City of Albuquerque

Re: OTONO PLAZA, BUILDINGS C, D, & E
4906, 4908 & 4910 Alameda Blvd. NE
Approval of Permanent Certificate of Occupancy (C.O.)
Engineer's Stamp dated 07/11/2003 (C-17/D115)
Certification dated 06/21/2004

RE: Otono Plaza Grading & Drainage Plan (C-17/D115)
Engineer's Stamp Dated May 8, 2003

The above referenced grading and drainage plan received May 9, 2003 is approved for Site Plan for Subdivision and Site Plan for Building Permit action by the DRB. Prior to Building Permit approval the following comments must be addressed:

GRADING & DRAINAGE PLAN

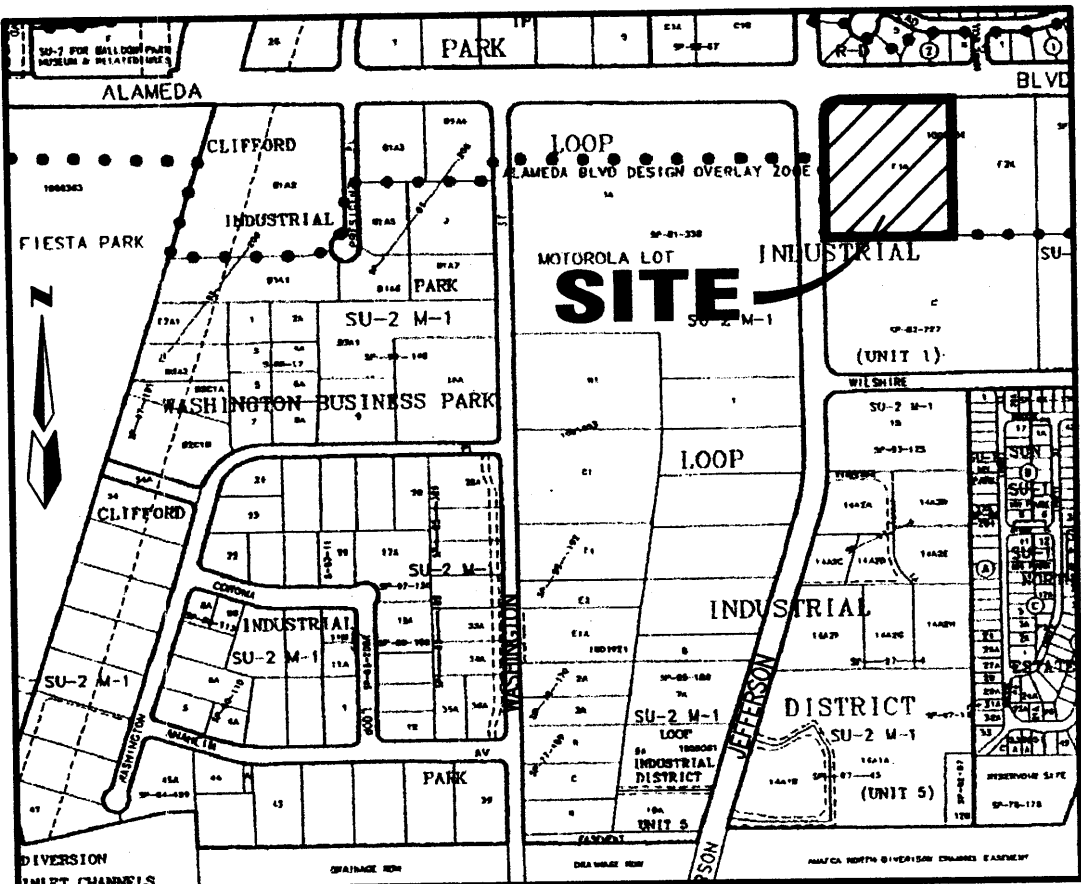
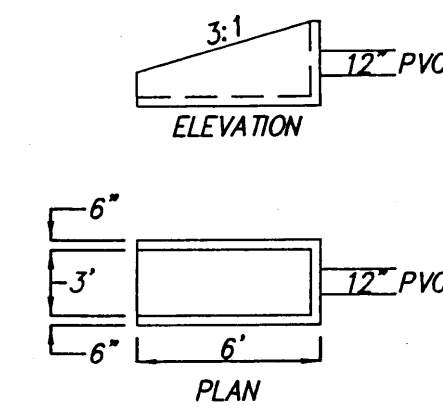
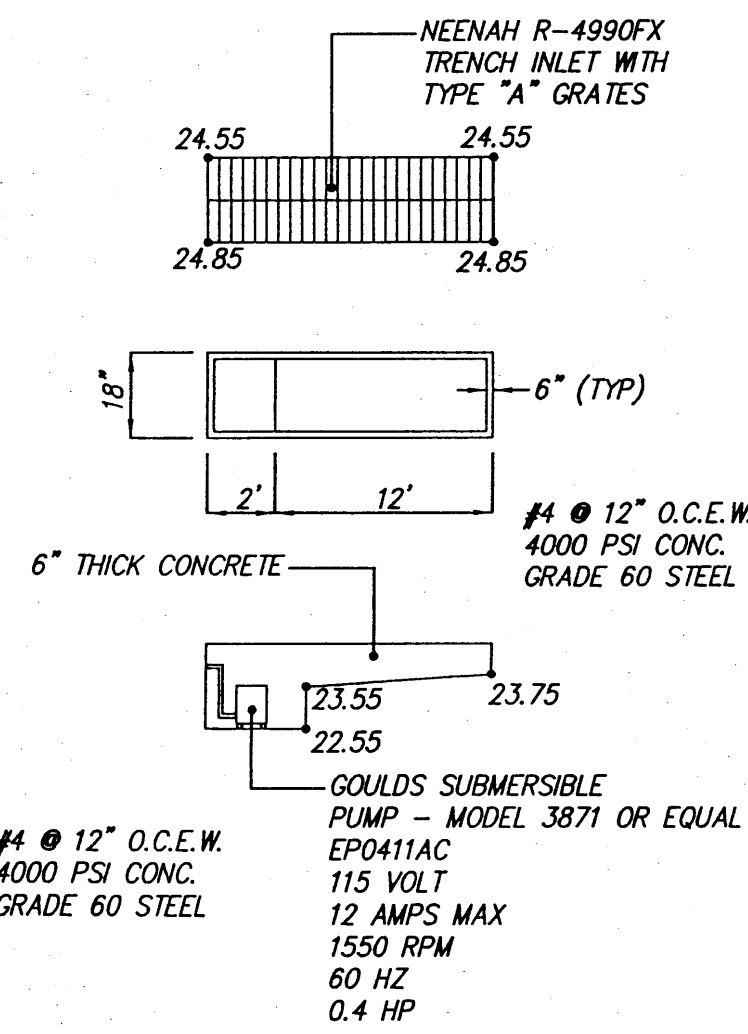
- Please show how runoff from Phase I will not erode Phase II area. Show interim drainage for Phase II while Phase I is being built.
- How is the runoff on the southwest corner of the site going to be controlled?
- Are there any offsite flows? If so, please quantify.
- Please provide duplicate plan for Storm Drain Inspector for building permit.
